# OBSERVATION/SUBMISSION TO PLANNING APPLICATION

**Case Reference: 324113**

Re: Observation to the proposed development of open-cycle gas turbine (OCGT) and generator with ancillary equipment.

Location: Pollnagroagh and Rathmorrissy (Townlands), Athenry, Co. Galway.

Purpose		PLANNING			
Title		SITE ACCESS SIGHTLINES			
Original Scale	Design/Drawn	Checked	Authorised		
SHOWN at A1	PS	ND	AJB		
Date	Date	Date	Date		
01.12.25	01.12.25	01.12.25	01.12.25		
Status	Drawing Number	Rev			
A2	PEK3-ATK-ZZ-01-DR-CE-901200	0

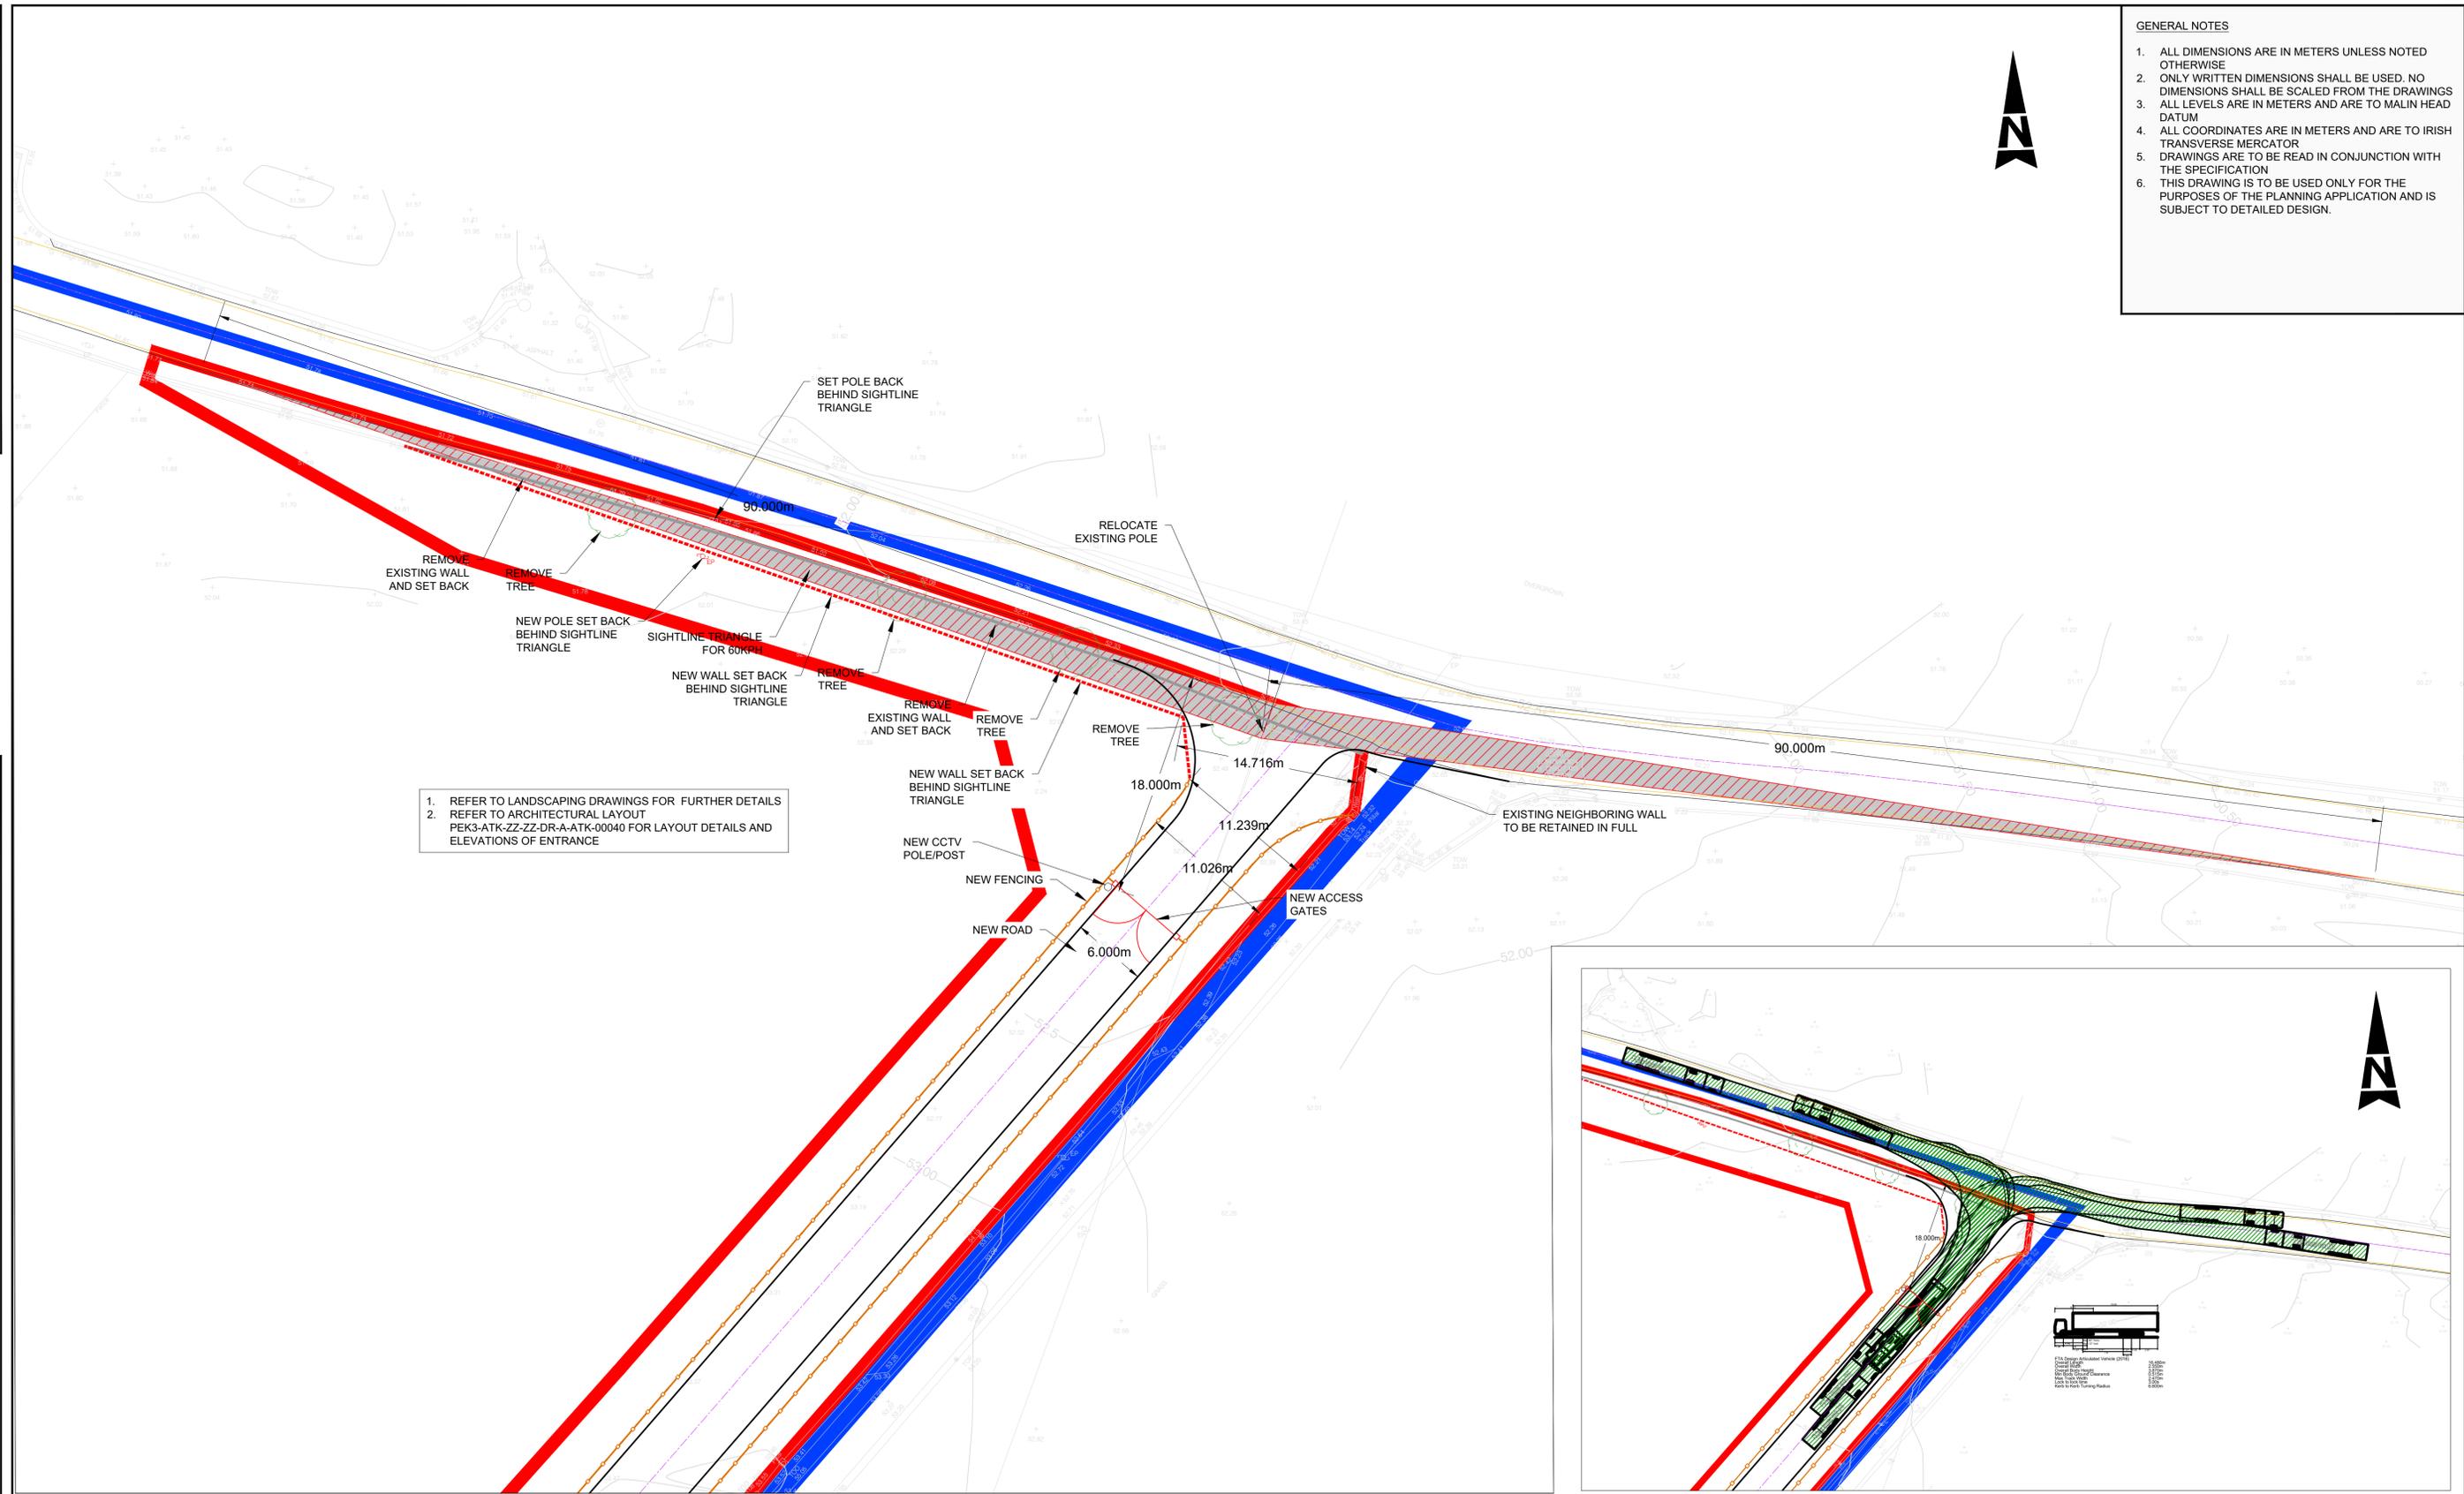
It would be beneficial to have further clarity on whether the Environmental Impact Assessment has fully captured road safety considerations associated with the proposed site access onto the L3103.

This road is relatively narrow, with limited verge space and constrained visibility in places due to bends and gradients. The introduction of construction traffic, operational vehicles, and fuel deliveries, including heavy goods vehicles, raises questions as to whether the existing road network can safely accommodate this level of activity.

Further consideration of the interaction between heavy vehicles and existing road users, including residents, agricultural machinery, and school-related traffic, would assist in ensuring that road safety implications are fully understood.
